ASSESSMENT REPORT

CUDGEN LAKES SAND QUARRY Modification 1 – Temporary Processing Area (05_0103 MOD 1)

Figure 3 – Temporary Processing Area

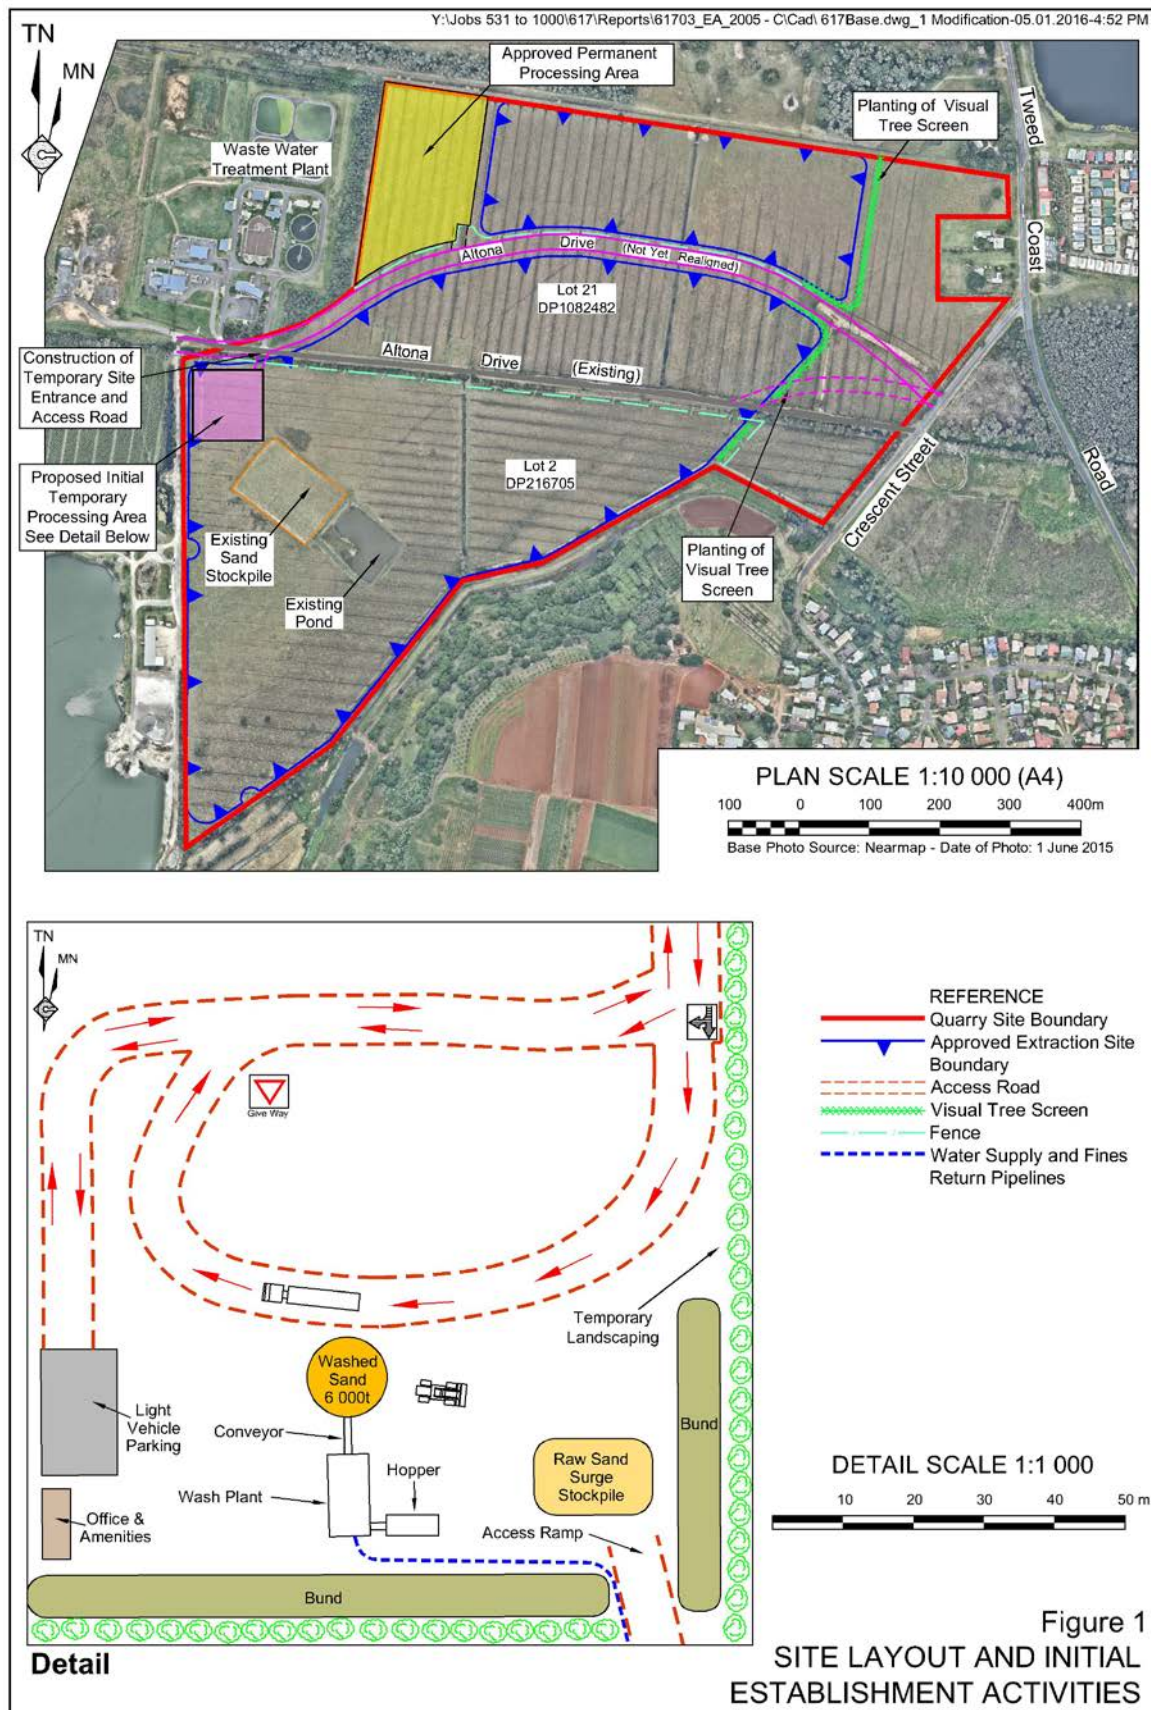
To provide clarity, Gales-Kingscliff submitted a diagram which confirmed the temporary processing area would be filled to the same level as the flood bunding around the entire project site required as part of the original project approval. Council was then satisfied that this filling would not have a significant adverse impact on local or regional flood behaviour above that of the approved development, since the primary control on flood behaviour would continue to be the bunding around the overall site. Council requested that conditions limit the fill pad in the proposed temporary processing area to a level of RL 1.8 m AHD (excluding acoustic barriers, stockpiles, equipment and buildings).

The Department is satisfied that the proposal would not have a significant adverse impact on flood behaviour and has recommended a condition to limit the fill pad to a level of RL 1.8 m AHD.

Alternative office locations with water tank

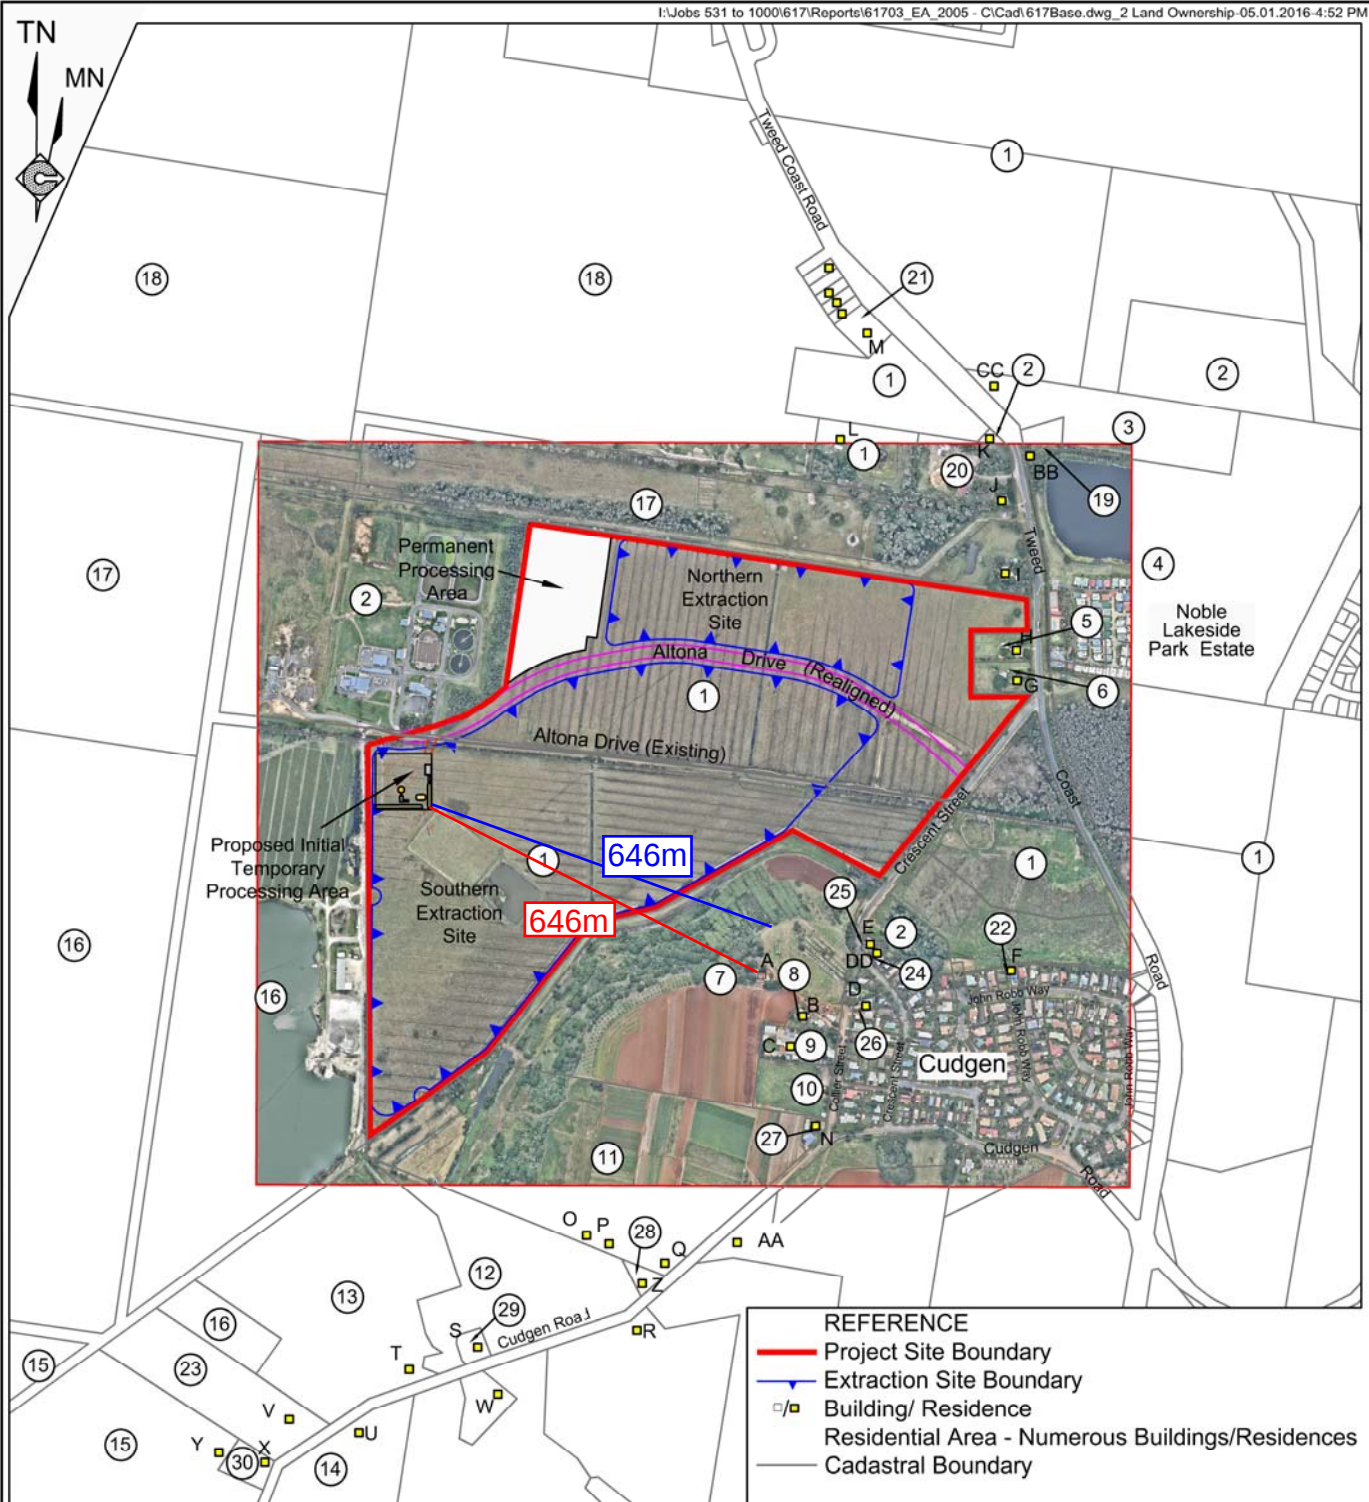
The proposed temporary processing area is located adjacent to Council's WWTP. Council raised concern over the location of the temporary office facilities within the proposed processing area, as its DCP sets a 200 m 'no development' buffer (with the exception of open air facilities) around the WWTP.

In response, Gales-Kingscliff proposed two alternative locations for the temporary office facilities, located at 200 m or 240 m from the WWTP (**Figure 5**). The Department has recommended that the furthest location of 240 m be adopted and that the office facilities are designed and constructed according to the requirements of the DCP including:

Figure 2
SURROUNDING LAND OWNERSHIP
AND PRINCIPAL RESIDENCES

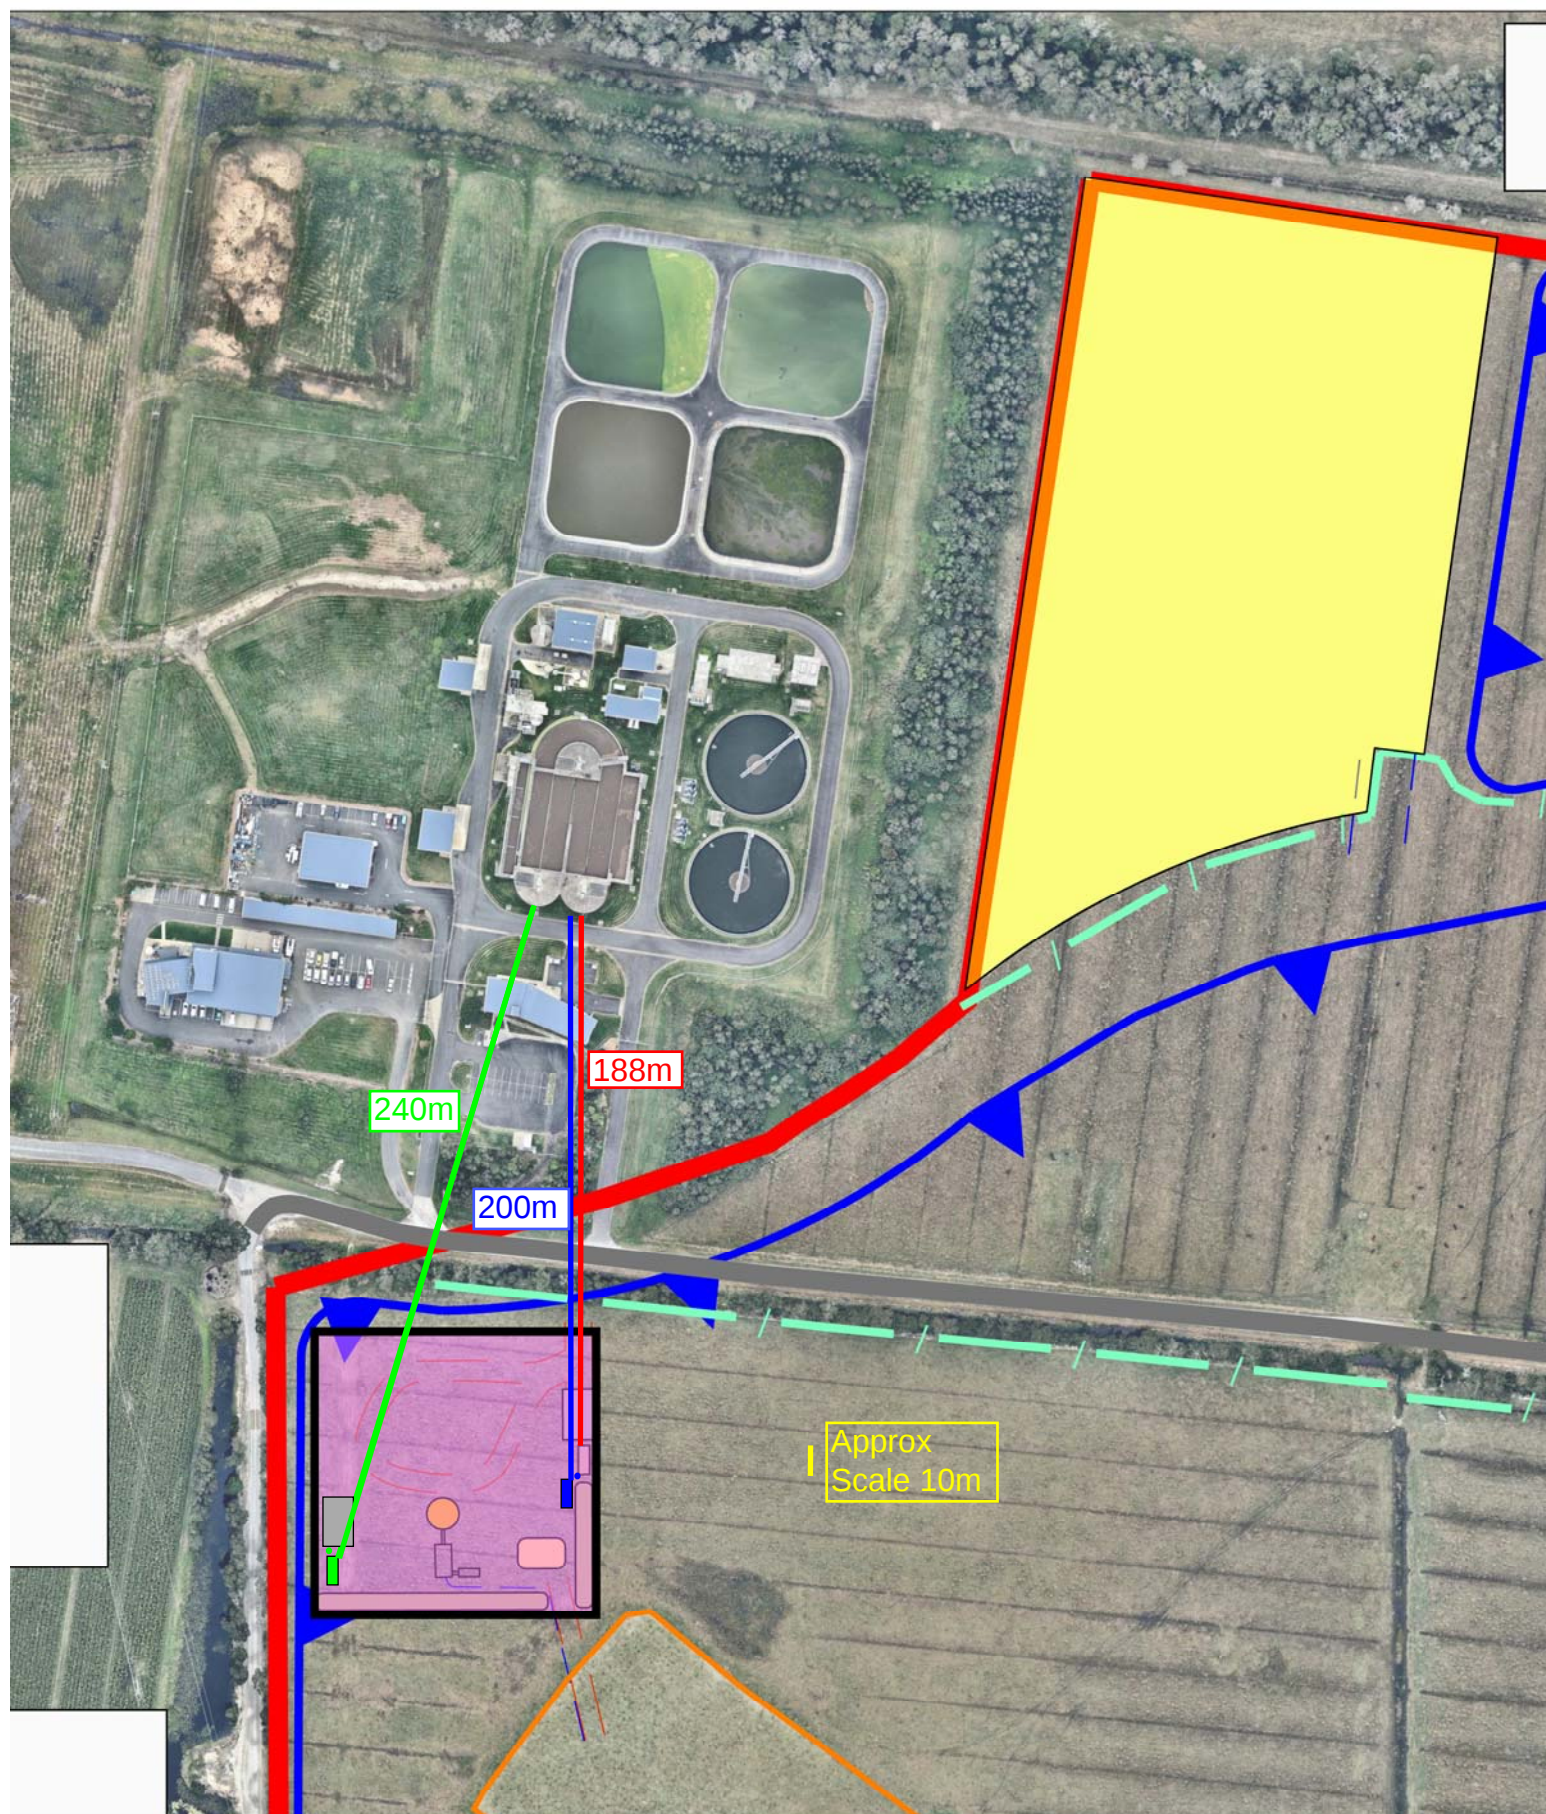
Council requested that additional assessment be undertaken for air quality impacts on a recently-approved 40-lot subdivision to the southwest of the proposed temporary processing area. Gales-Kingscliff's RTS clarified that Residence A (which is considered in the AQIA 2015), is at the same distance as the closest subdivided block within the approved subdivision immediately northeast of Residence A (**Figure 4**). Therefore, Gales-Kingscliff deemed this site representative of the 40-lot subdivision. The Department accepts this position.

The temporary processing area would be located approximately 200 m southwest of the approved permanent processing area, closer to residents to the south and southeast. The NIA 2015 labelled the closest receivers to the temporary processing area as B, DD and O (**Figure 4**). In response to Council's submission, the Department requested that noise modelling was undertaken for the recently-approved 40-lot subdivisions.
